CITY OF ALBUQUERQUE

August 20, 2024

Re: Dutch Bros Coffee- 7330 San Antonio Dr NE
Traffic Impact Study (E19D025C2)
Engineer's Stamp 8-16-24
Via email buy@barghausen.com

The subject Traffic Impact Study (Study) received on August 16, 2024, has been reviewed and is approved by the City of Albuquerque Planning Development Transportation Section.

PROPOSED OFFSITE IMPROVEMENTS
7330 SAN ANTONIO DR NE
ALBUQUERQUE, NM 87109

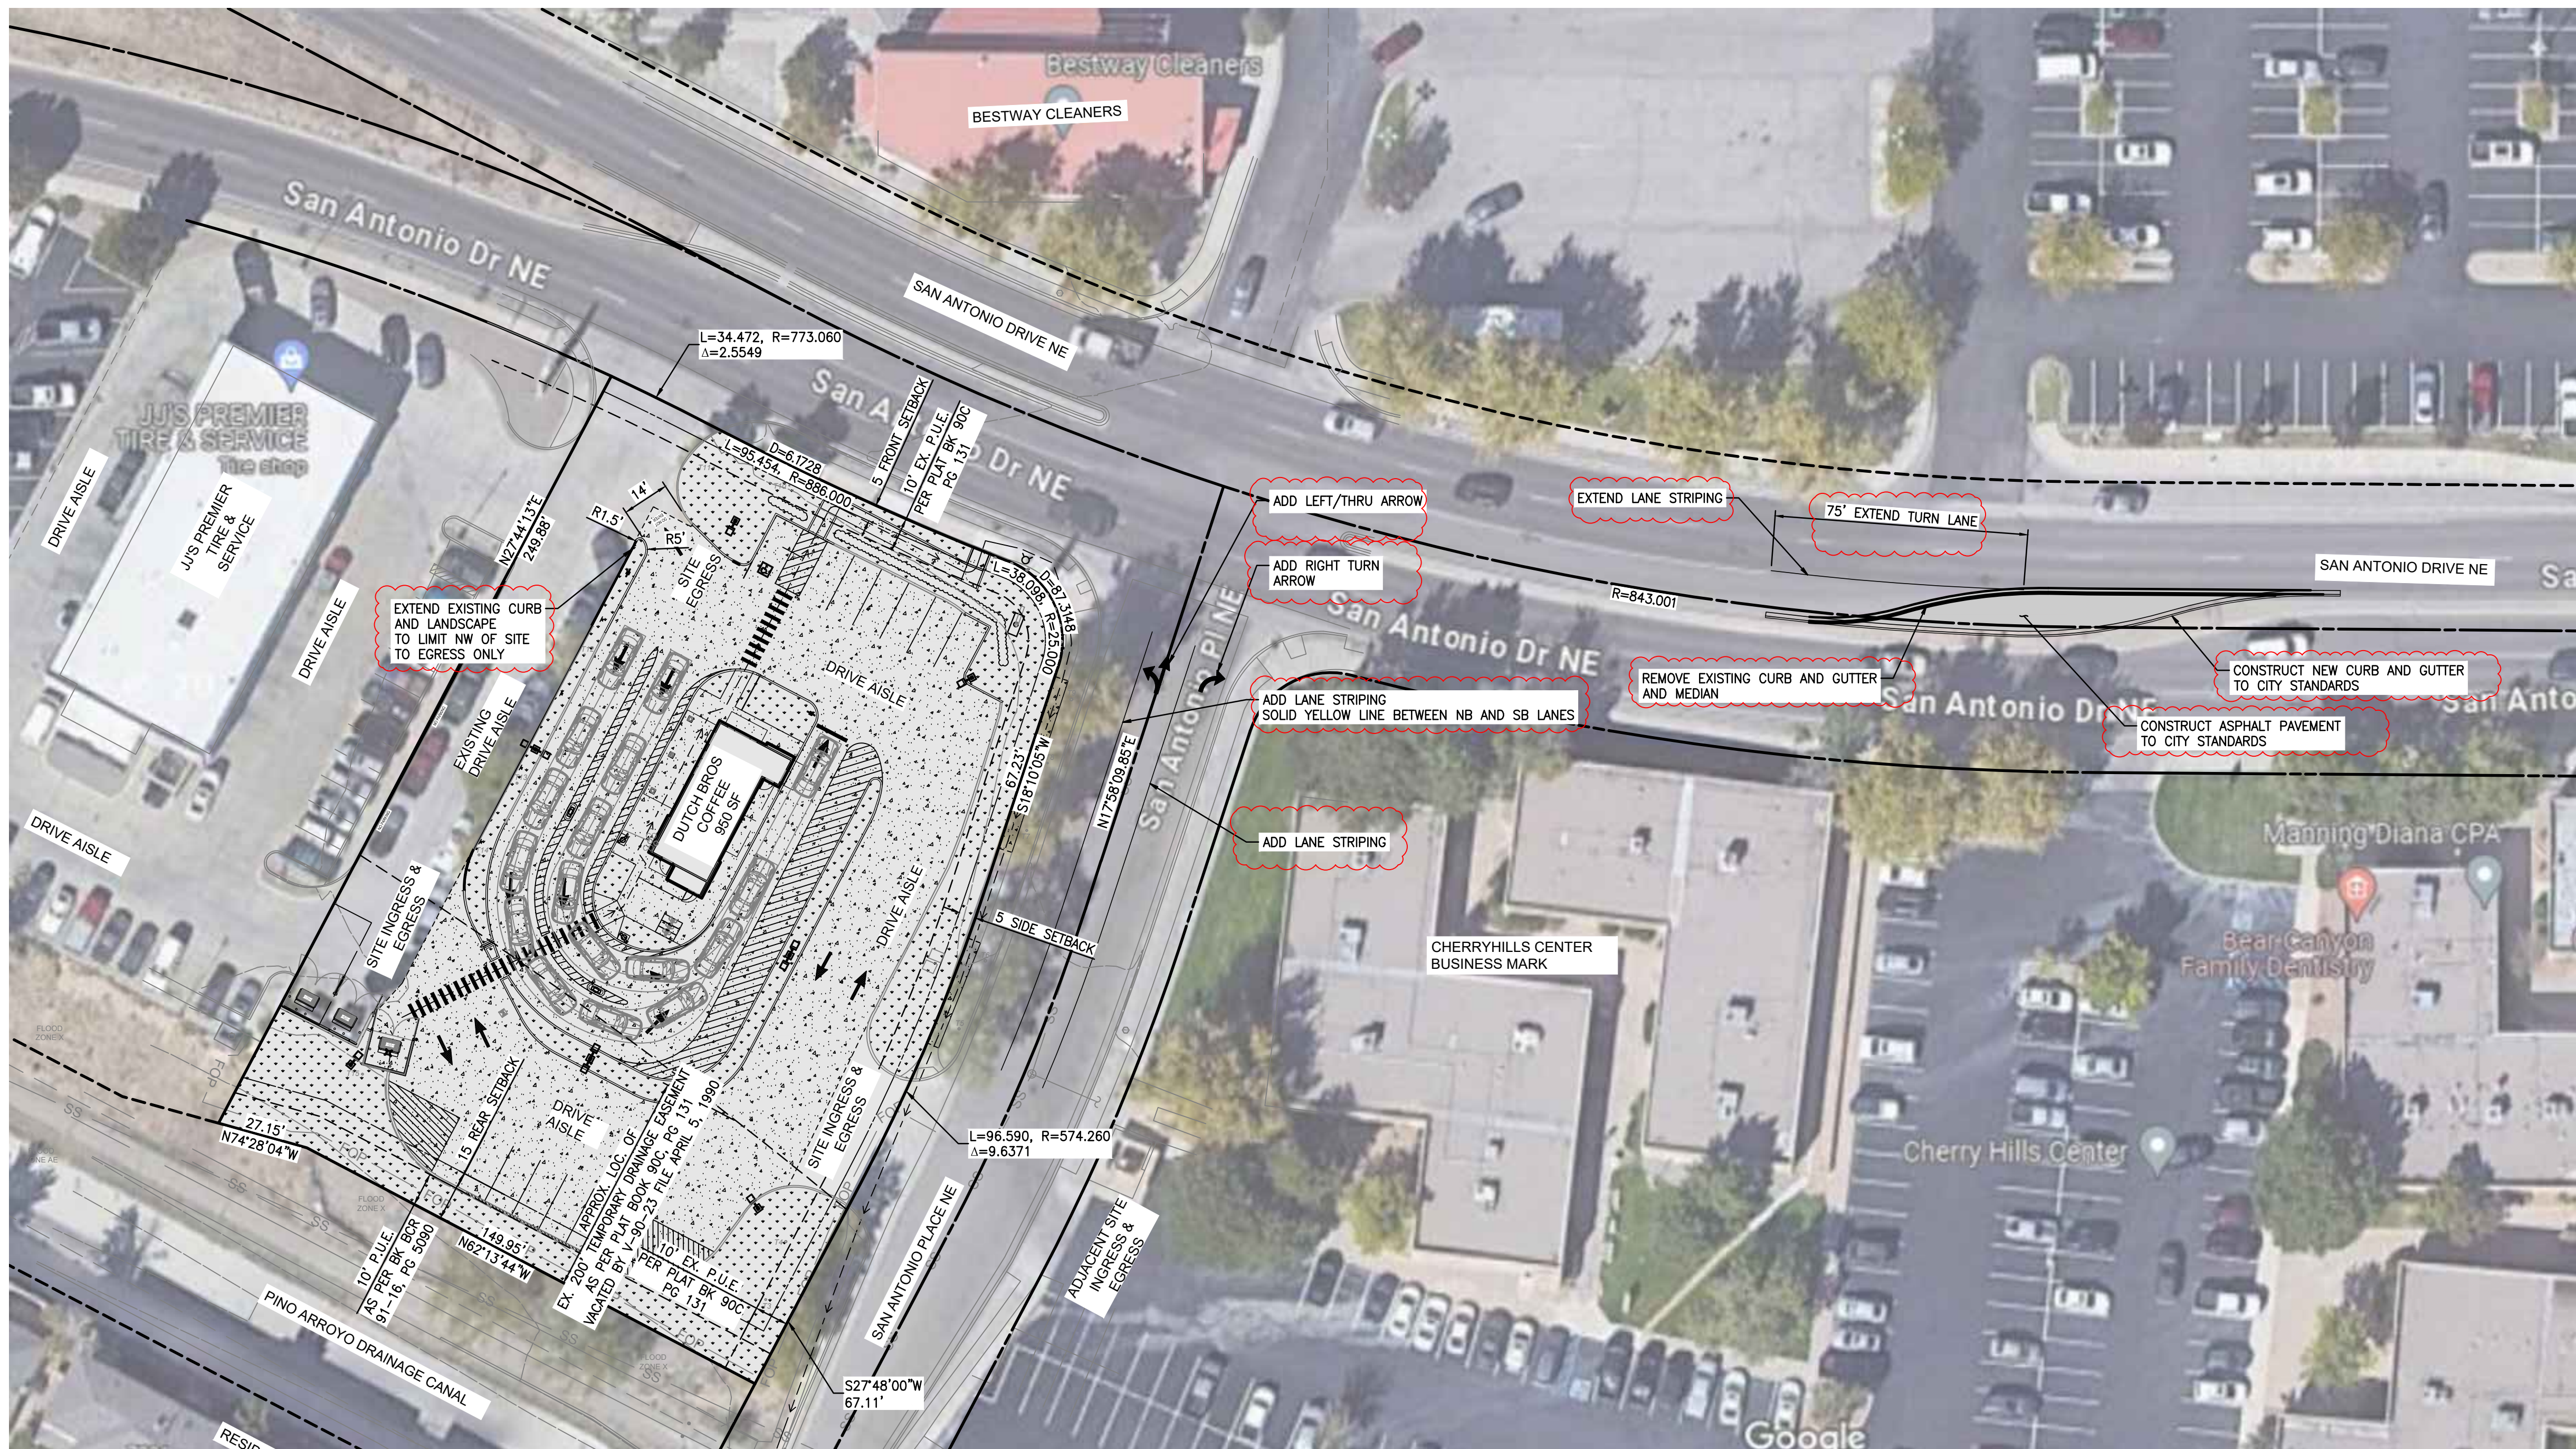
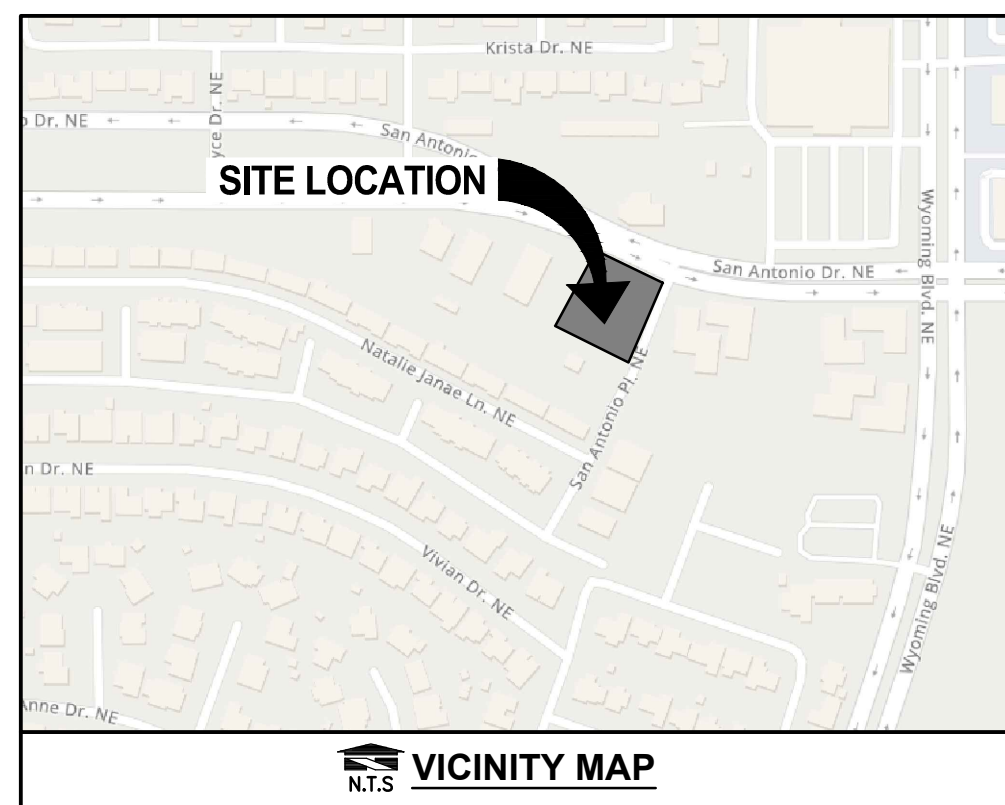
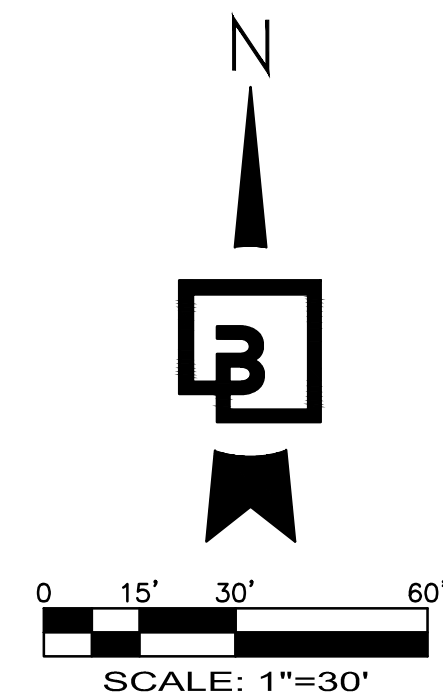
Required infrastructure improvements per the Study as shown on the Site Plan p. A.2 include :

1. Extend the westbound left-turn pocket by 75 feet at the San Antonio Place NE/San Antonio Dr NE intersection
2. Separate northbound right-turn/ pocket at the San Antonio Place/ San Antonio Dr intersection.
